A drainage report will be required prepared and signed by a Colorado licensed engineer. Please see uploaded checklist for reports requirements

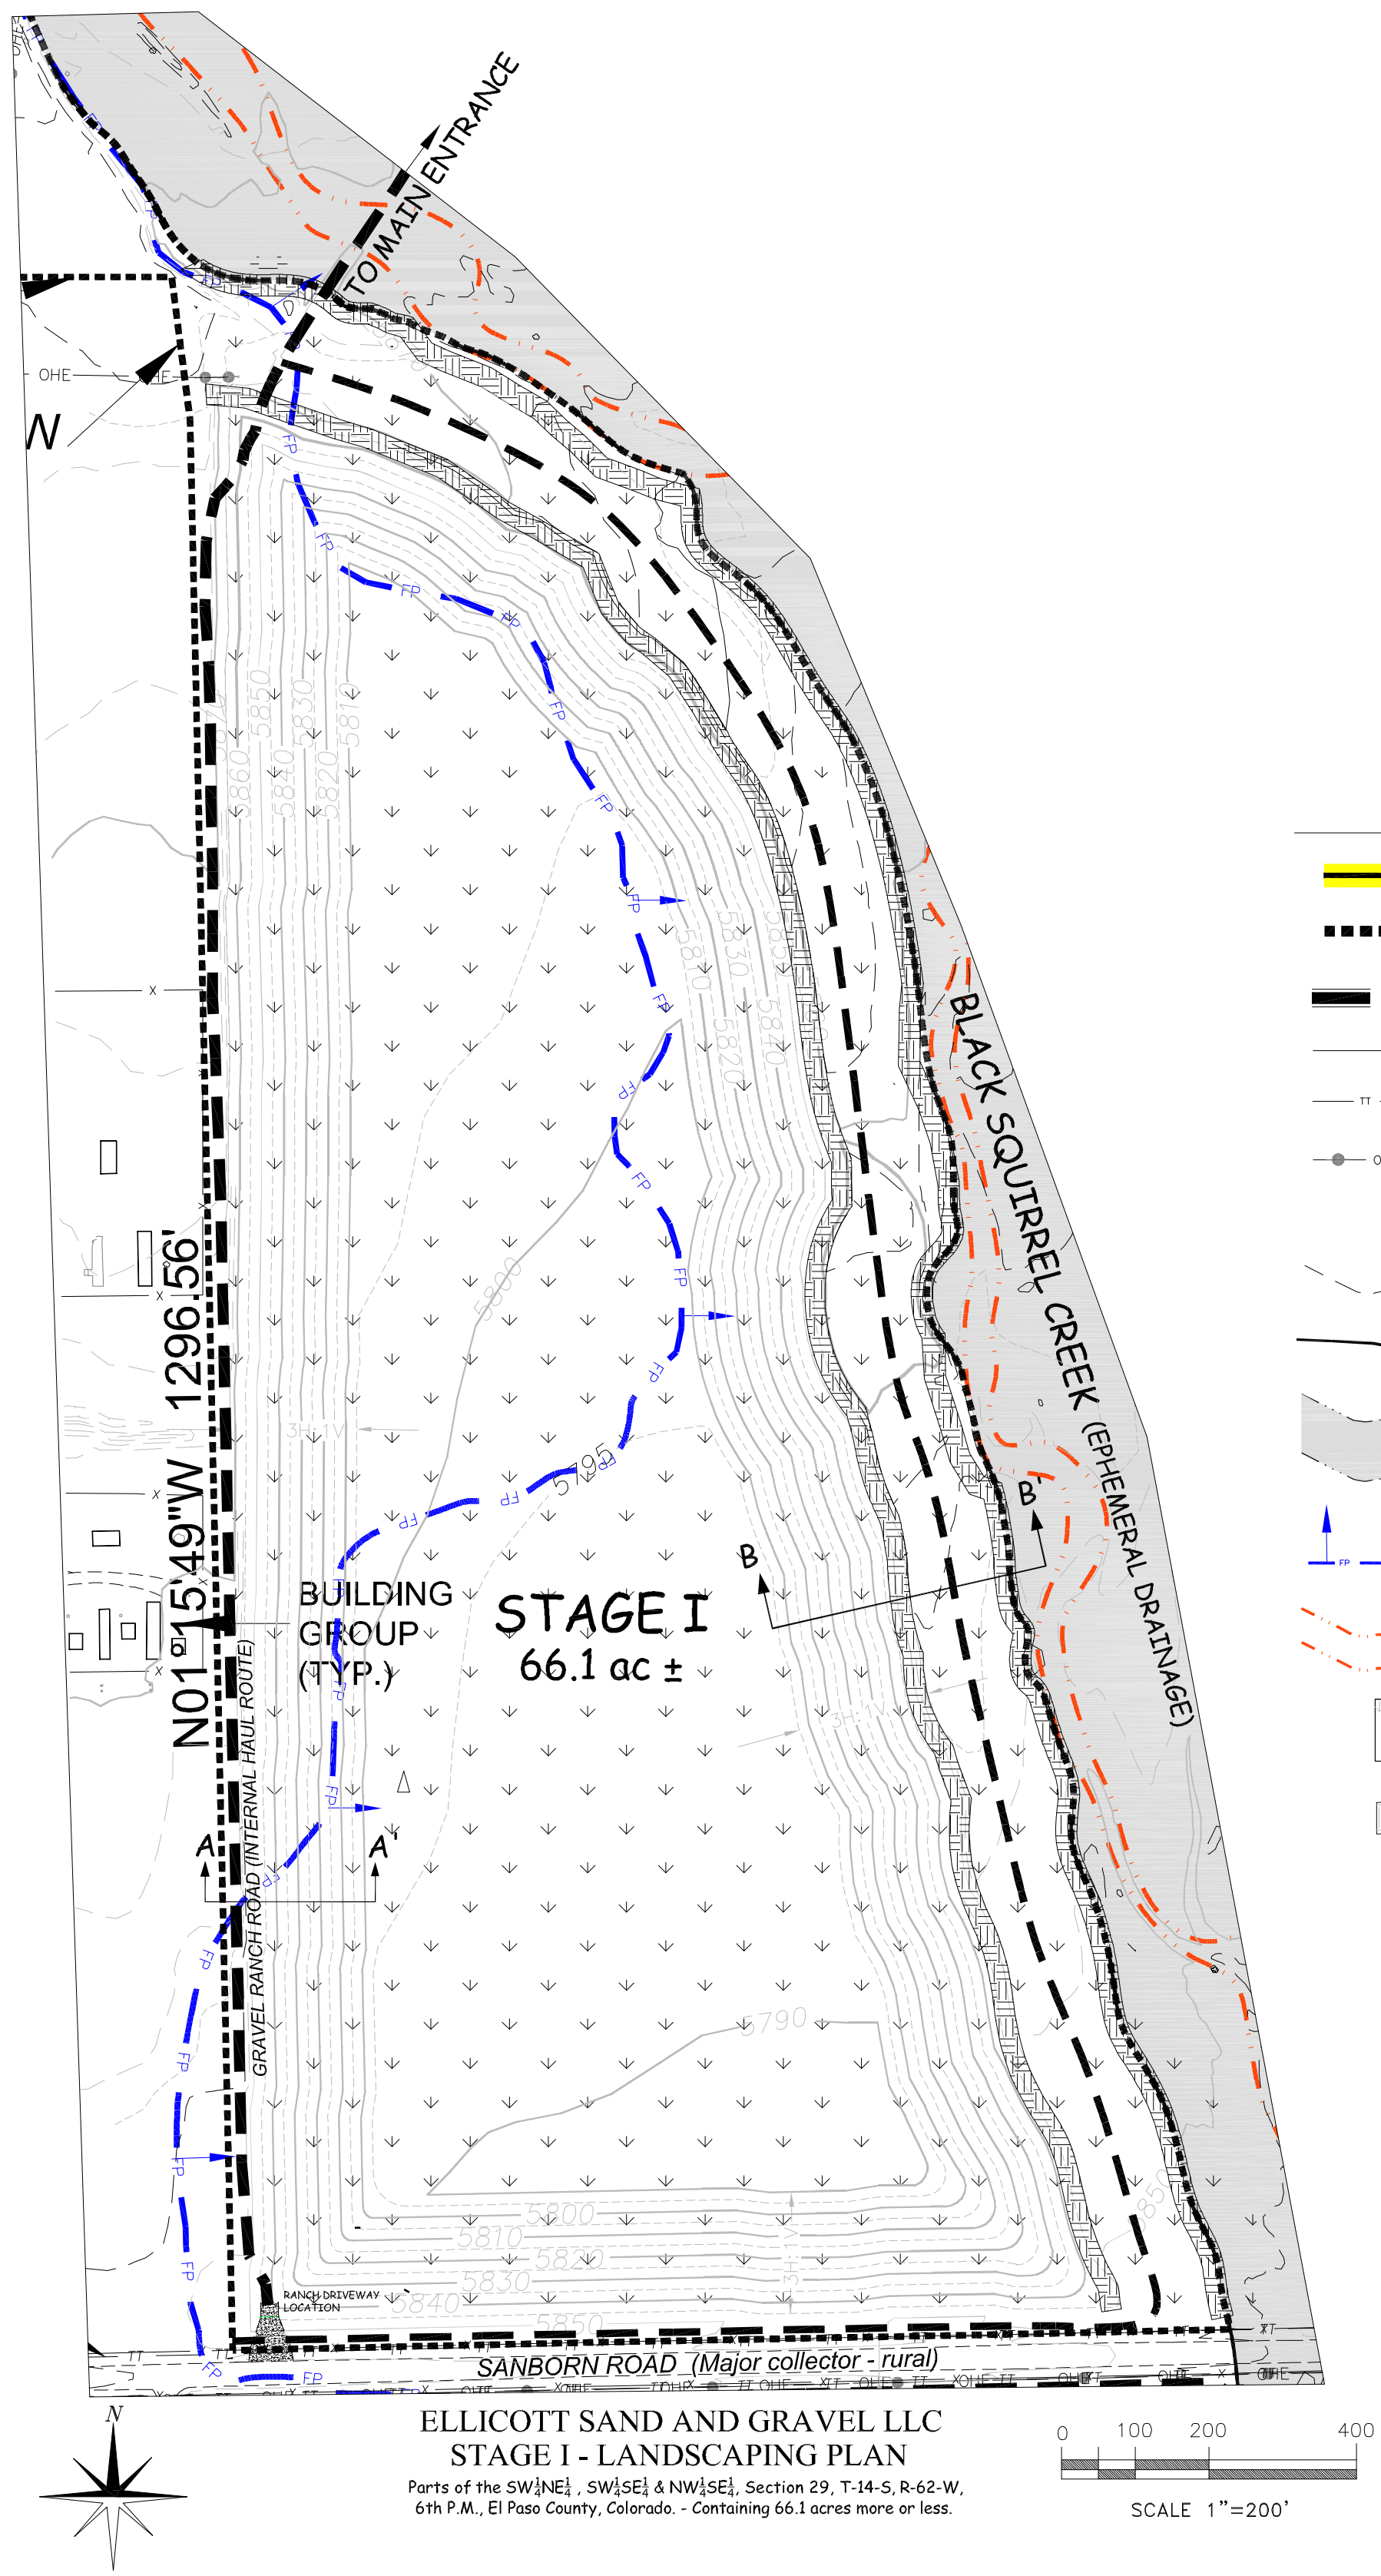
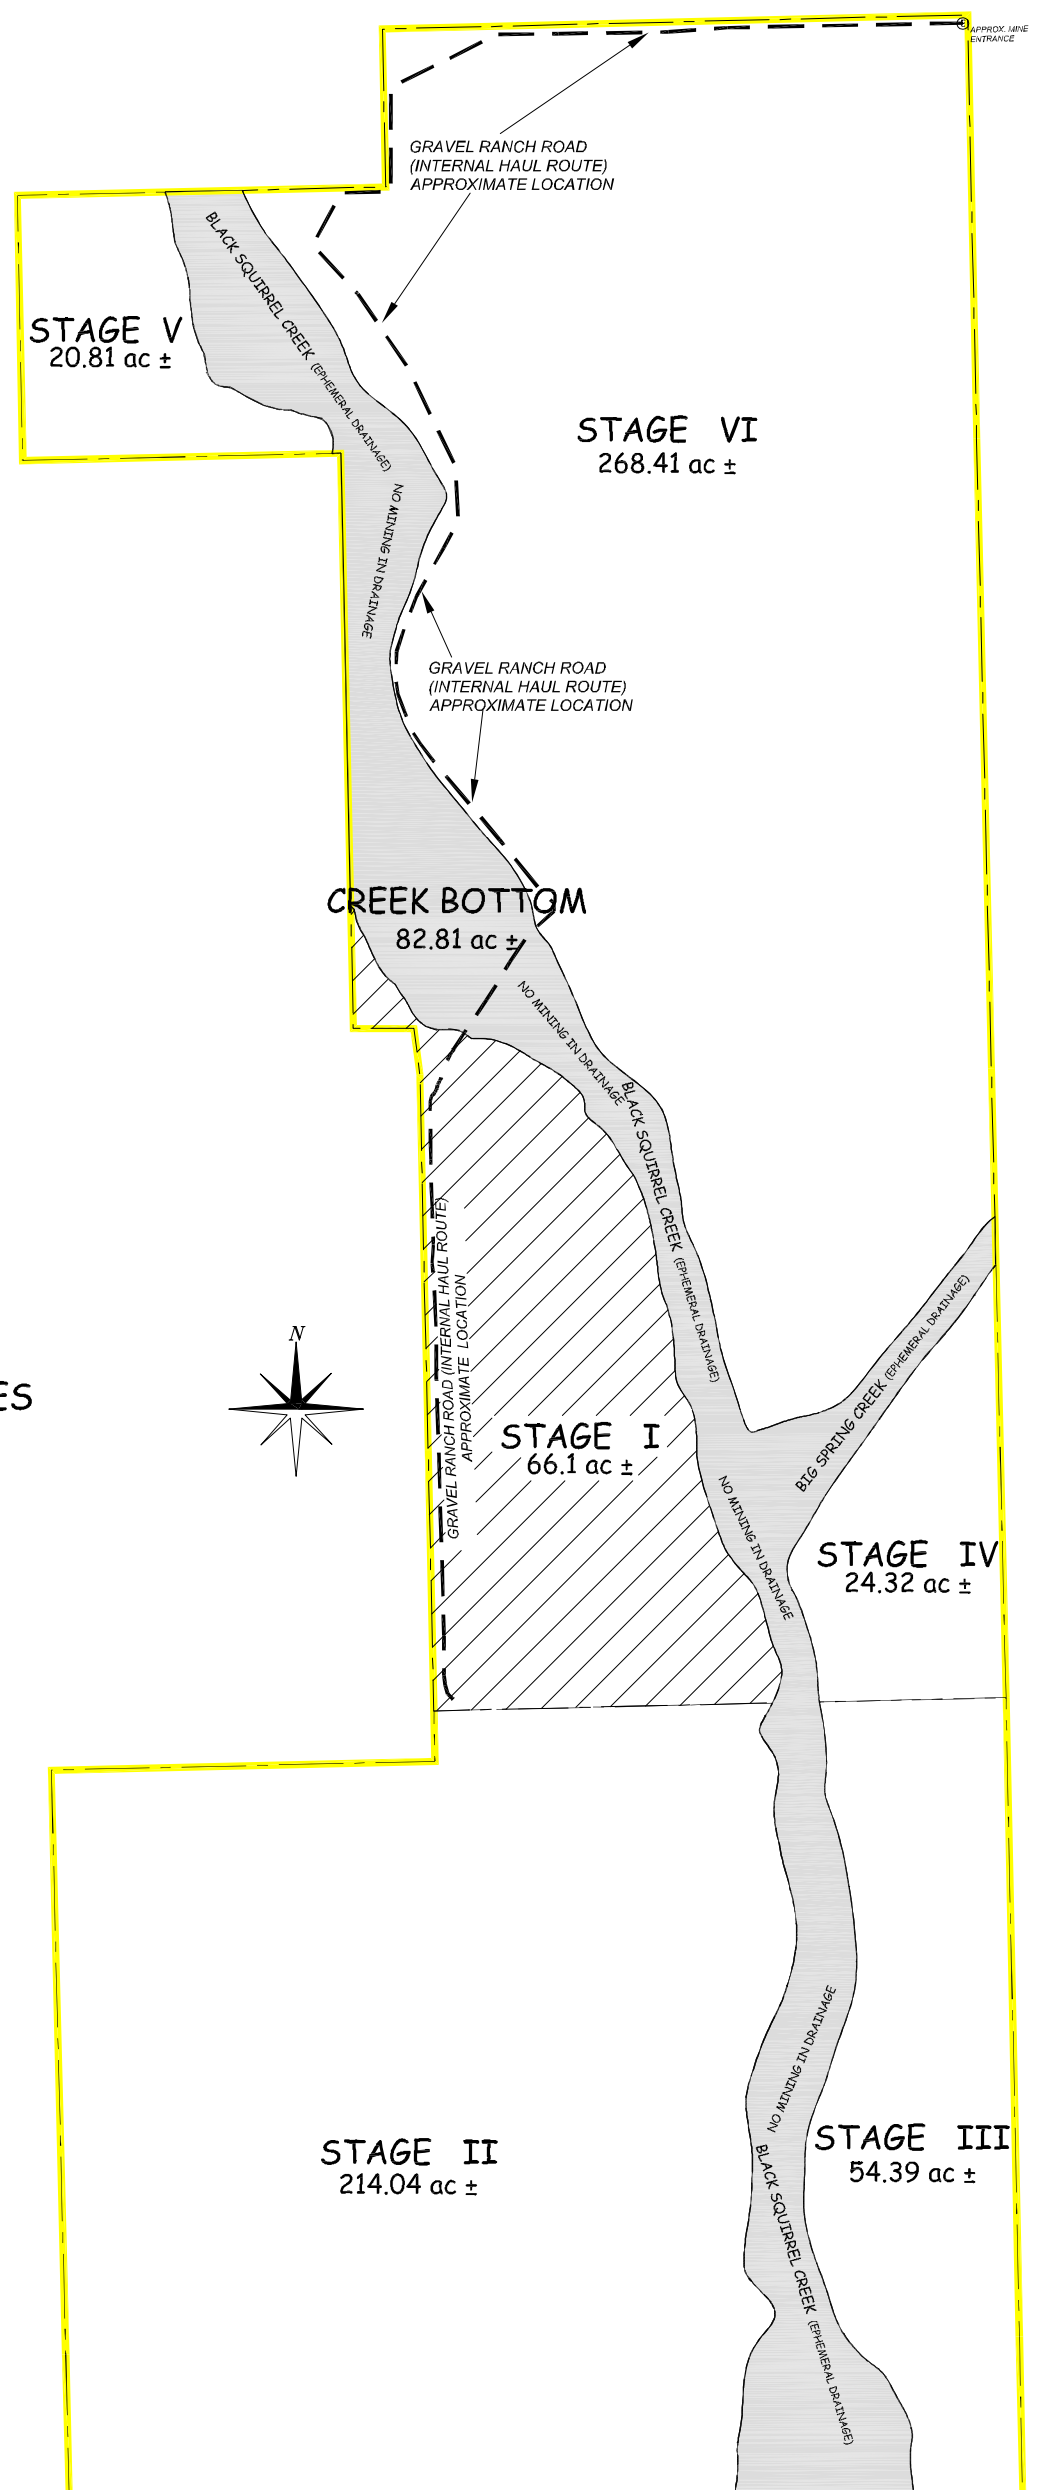
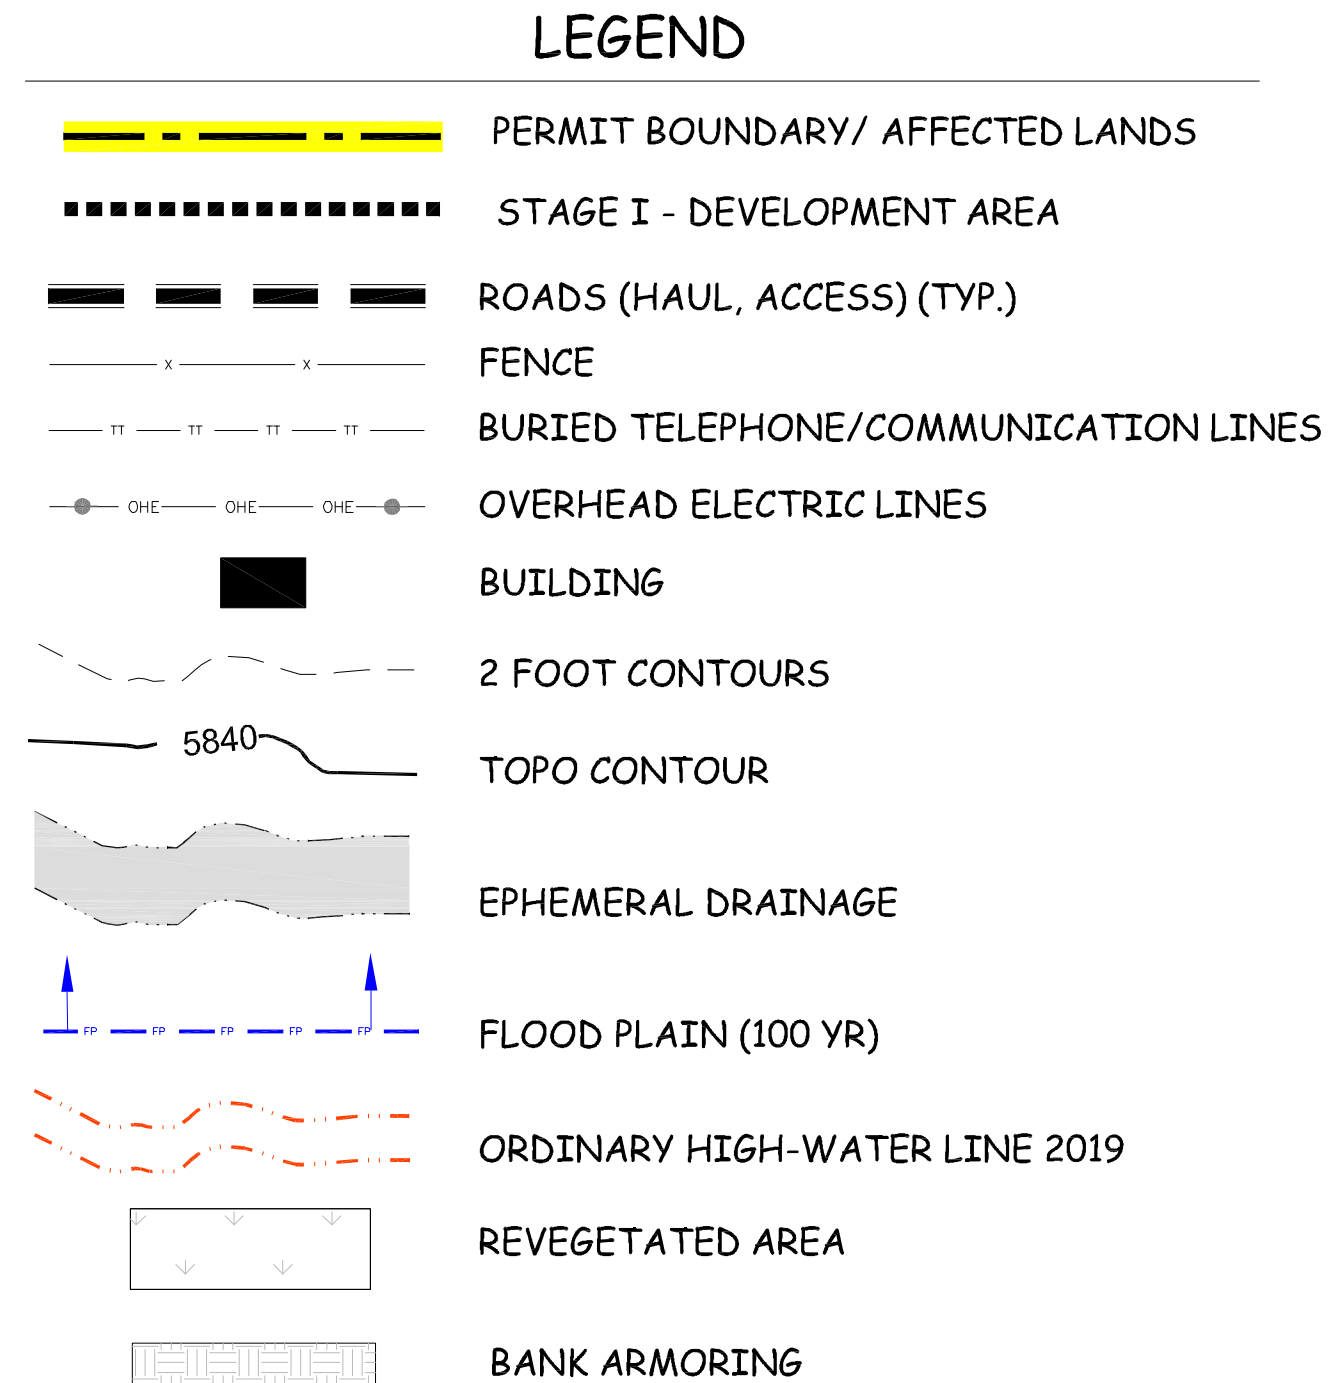
In WQ section of report, discuss site's need for a CDPHE Industrial Permit (which is notated on bottom left corner of sheet 1 of GEC Plans):
